Appendix TA - D

**HIGHWAYS ENGLAND
CONSULTATION RESPONSES**

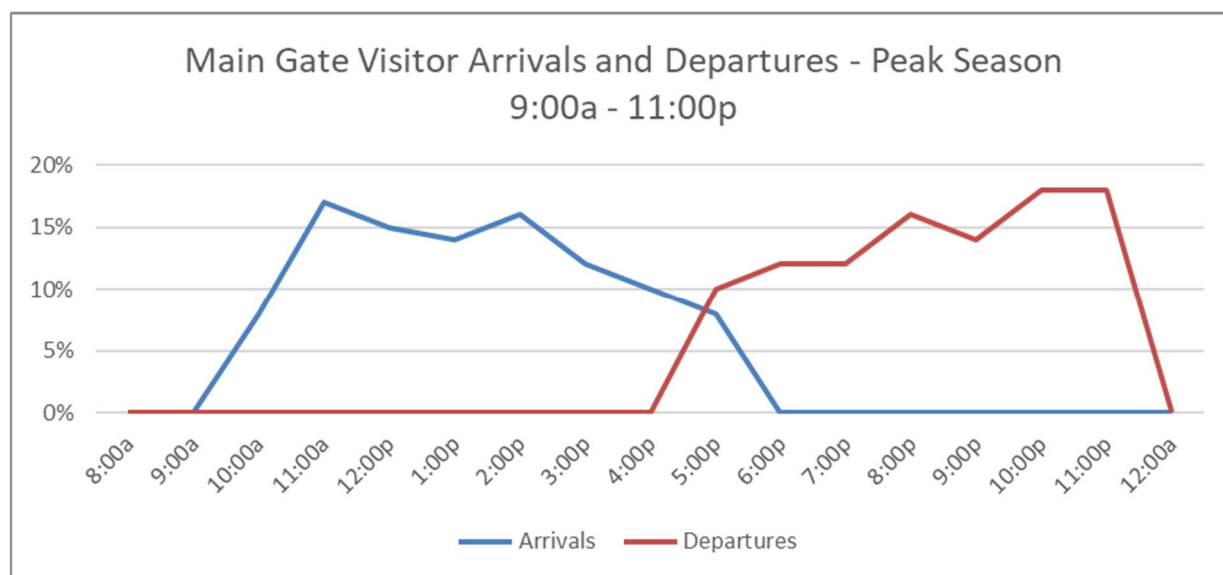
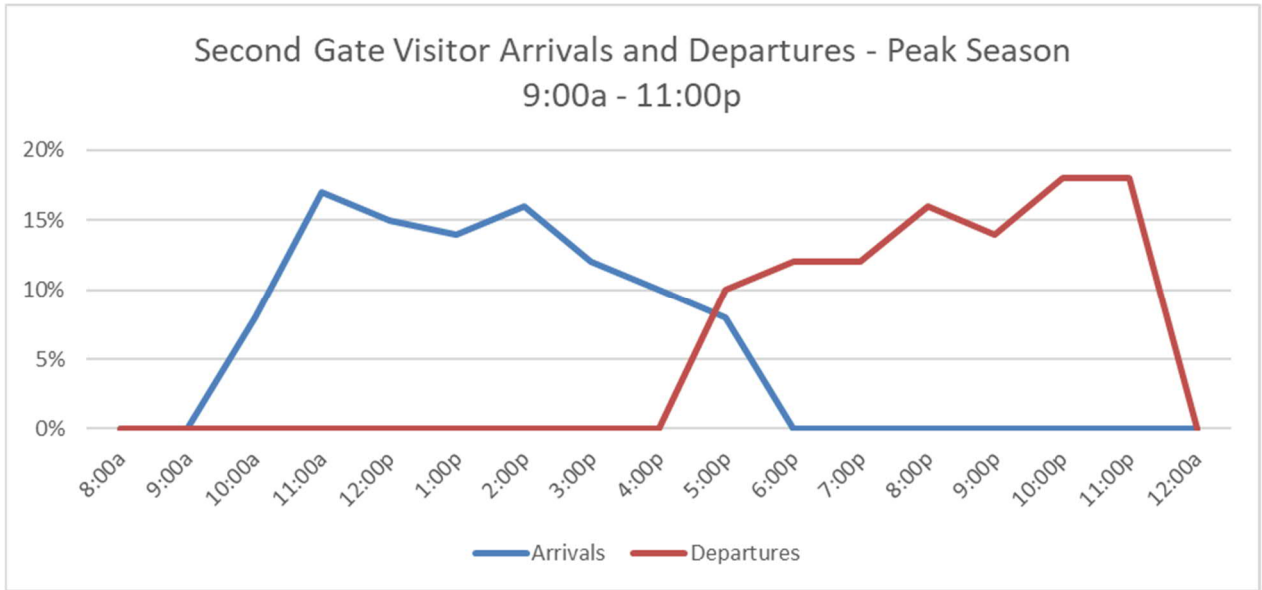
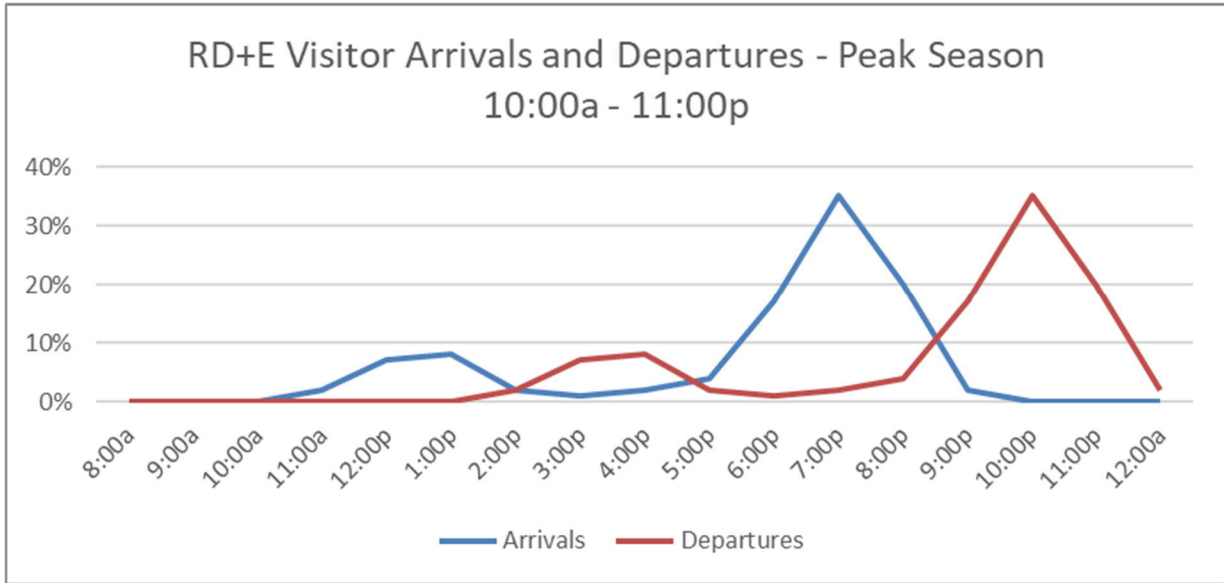
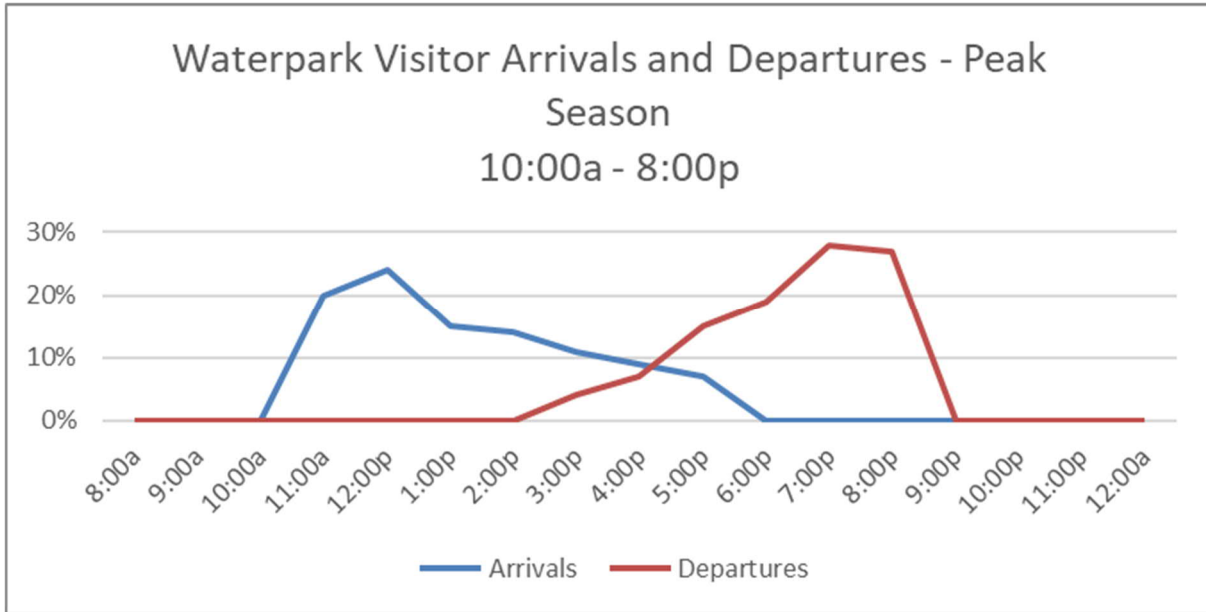
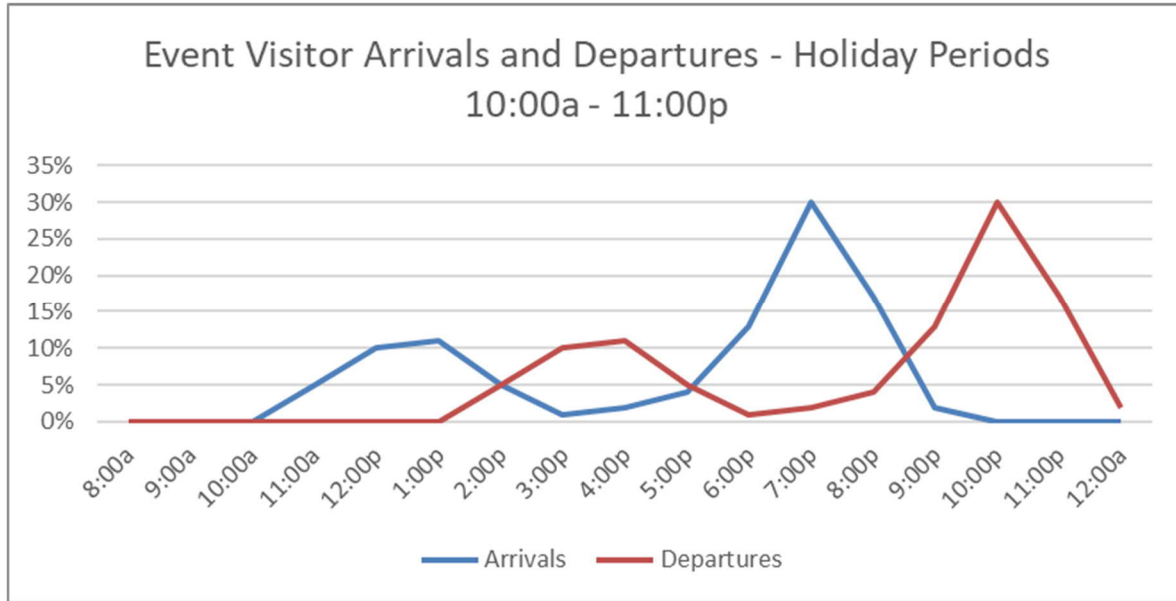
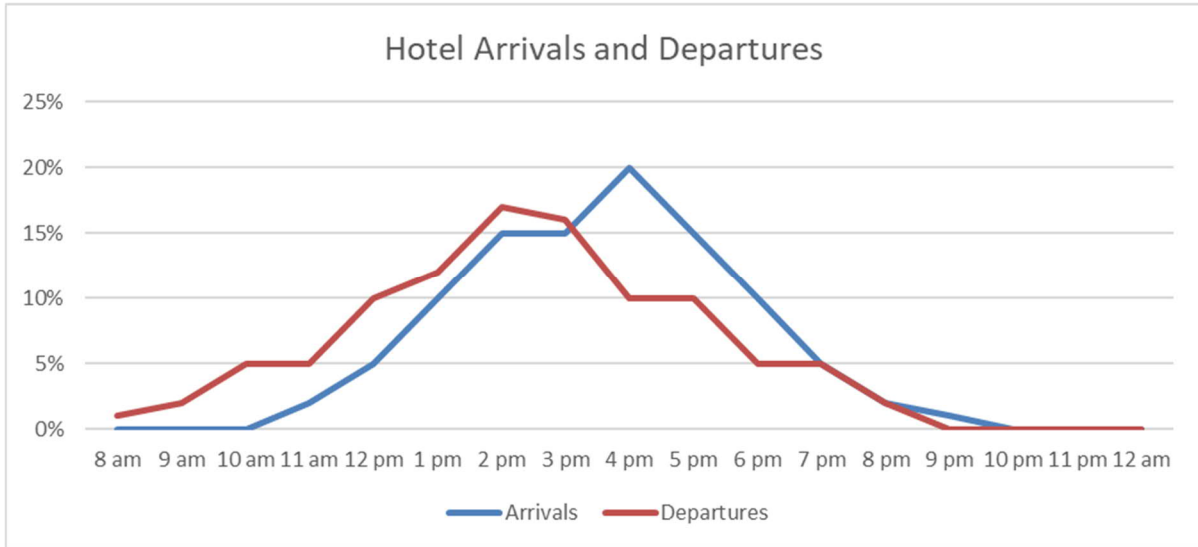
Highways England	Stakeholder Advisor Technical Document	Chapter 5	Graphical Arrival and departure profiles	The graphical arrival and departure profiles for each part of the Resort in Chapter 5 correspond directly with, for example, the hourly visitor arrival and departures from each element of the resort in Table 14. The figures in Table 14 correspond with the visitor arrival and departure totals in Table 6-1 of the Trip Generation report. This suggests that the trip arrival and departures in the trip generation report do not take the time for cross visitation into account. If this were the case, the hourly arrival and departure trips would require modification to reflect the extended time in the Resort for cross-visitation.	The Profun profiles already take account of the cross visitation
Highways England	Stakeholder Advisor Technical Document	Tables 14 to 16	Arrivals and departures for visitors and staff	It is apparent that the projected combined arrivals and departures are higher in the 1600-1700 (the highest total) and 1800-1900 hours than the traditional peak hour on the network of 1700-1800. Unless assurances can be made that guarantee lower arrivals and departures during the actual network peak hour than the previous or later hour or both (whether this is 1700-1800, 1600-1700 or 1800-1900), a more robust approach should be taken that recognises the possibility of an arrival and departure peak matching the network peak.	<p>Profun have developed the arrival and departure profiles based on industry data. The other land uses, such as RDE and Events have arrival and departure profiles that include trips within the traditional commuter peak periods. This is considered appropriate and reflective of the likely user profile at the London Resort. As noted above, a 17:00 - 18:00 hour will be assessed.</p> <p>An event management strategy, being developed by leading specialists that have experience of managing large scale events, will set out initiatives and measures that will control visitor flows. The numbers set out reflect that LRCH will implement strategies to run events etc to minimise travel in peak hour. Visitors will be made aware (e.g. through real time information) on external network congestion and hotspots which will manage peoples departure profile.</p>

Highways England	Stakeholder Advisor Technical Document		Arrival and departure profiles	What are the estimated total additional time for visitors parking at the main on-site car park and the Tilbury Dock car park to entering the Main Gate? If the time for this is significant there may be earlier arrivals and earlier departures throughout the day on the transport network than estimated at the gate.	A TN has been written which takes this into account. An adjustment, shifting profiles by half an hour and a peak half hour to take into account additional travel time, or transit time.
Highways England	Stakeholder Advisor Technical Document		Car Park Occupancy and Management	This will demonstrate whether the car park will be full throughout the day. Alternatively, further information should be supplied as to how car parking space will be managed throughout the day with differential arrival and departure profiles for different on-site attractions and uses. If a car leaves a full car park, under the worst-case scenario for visits and commutes by car will it be re-allocated to a new arrival? As mentioned above, even with car park management, those turned away, may seek to park on local street and walk/bus/taxi to the Resort, especially if they are seeking to use the RDE and not necessarily go through a pay gate. How will such scenarios be managed.	Further information will be set out in the Car Parking Management TN and ticketing management strategy. Measures to review impacts are set out in the Offsite Parking Technical Note.
